Consultation Response from: KC Environmental Health (Pollution & Noise Control)
2024/91917 land at 115 Westfield Lane, Wyke, BD12 9LY
Discharge of details reserved by condition 17 (Validation Report) of previous permission 2023/91472 for variation of conditions 9, 11, 12, 22, 23, 25, 27, 29, 30, 33, 34 and 38 of previous outline permission 2020/90436 for the demolition of one dwelling and erection of residential development and associated works with details for access
Responding Date:
31st July 2024

Comments
Condition 17- Validation

In support of the partial discharge of condition 17 a Phase 4: Validation Report, by Solmec Ltd, ref: S221109 has been submitted. We have reviewed the report and make the following comments.

TABLE 3: SUITABLE GROWING MEDIUM THICKNESSES

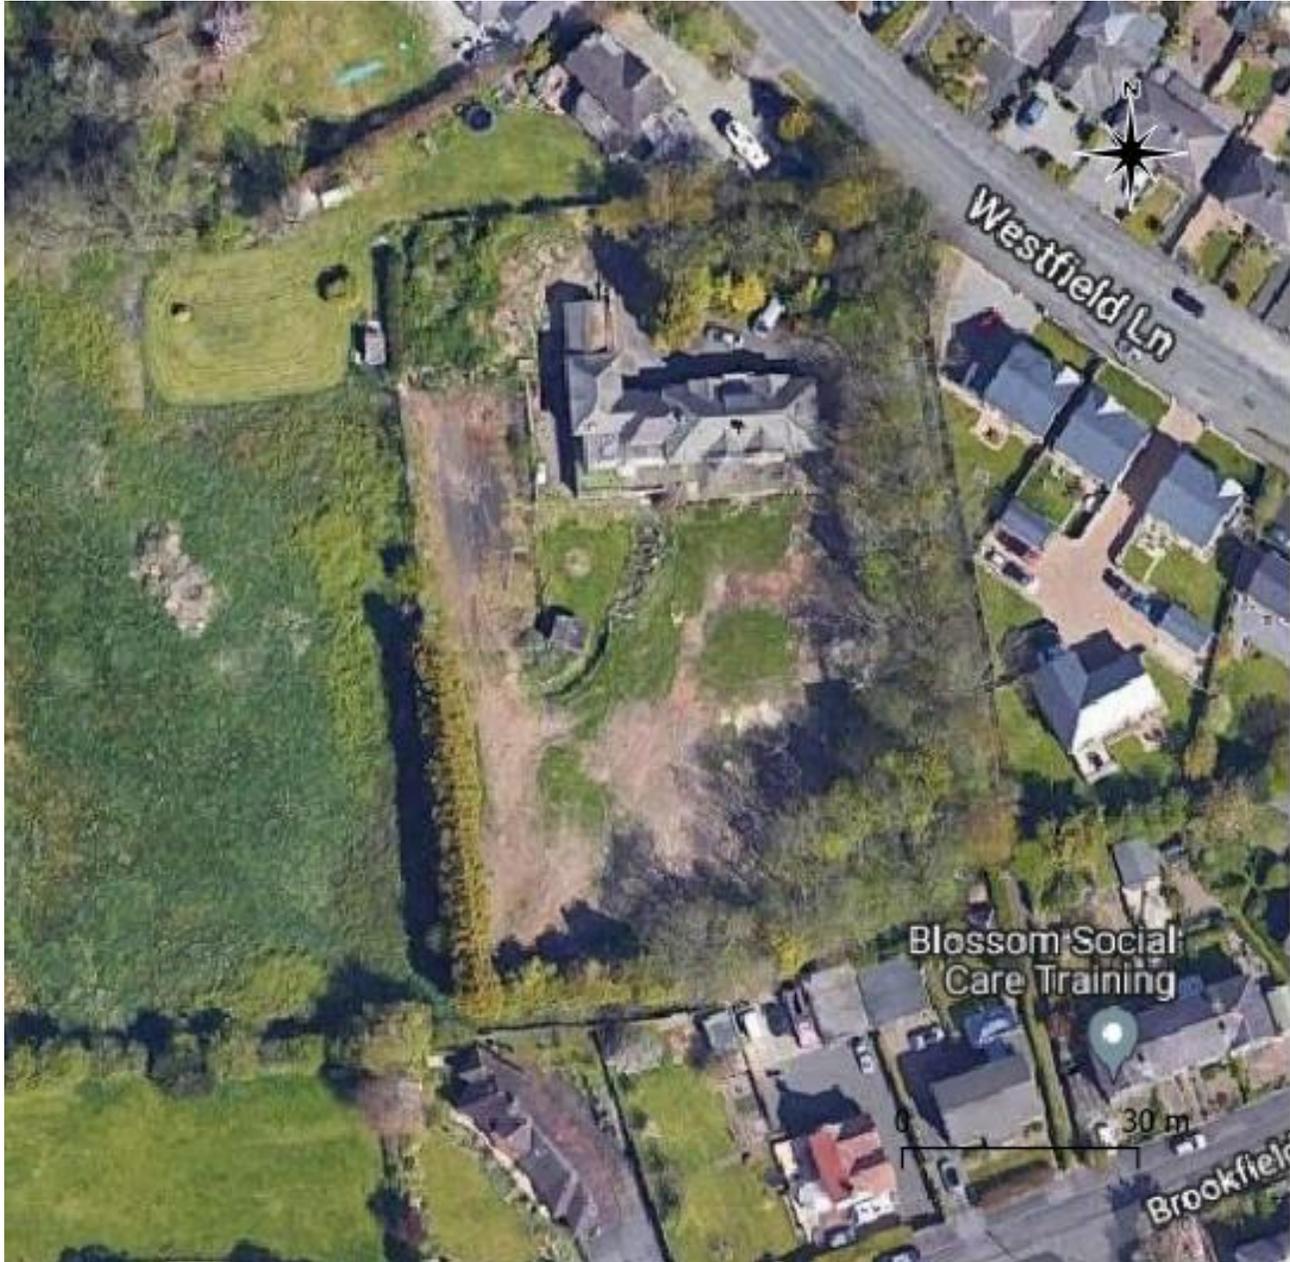
The report is in relation to plots 1 to 6 only it confirms imported topsoil and subbase has been applied to the garden areas of the plots to a total depth of 600mm. The report goes on to confirm depth of cover by way of description and photographs in plots 4,5&6.

Whilst we accept the depth of cover information and the test results to date, we are unable to accept the report at this time, for the reasons given above.

We would wish to see a more appropriate spread of photographic evidence across the plots in future reports, clear clarification regarding source/quantities and if sampling has been undertaken at source, from stockpiles or in situ.
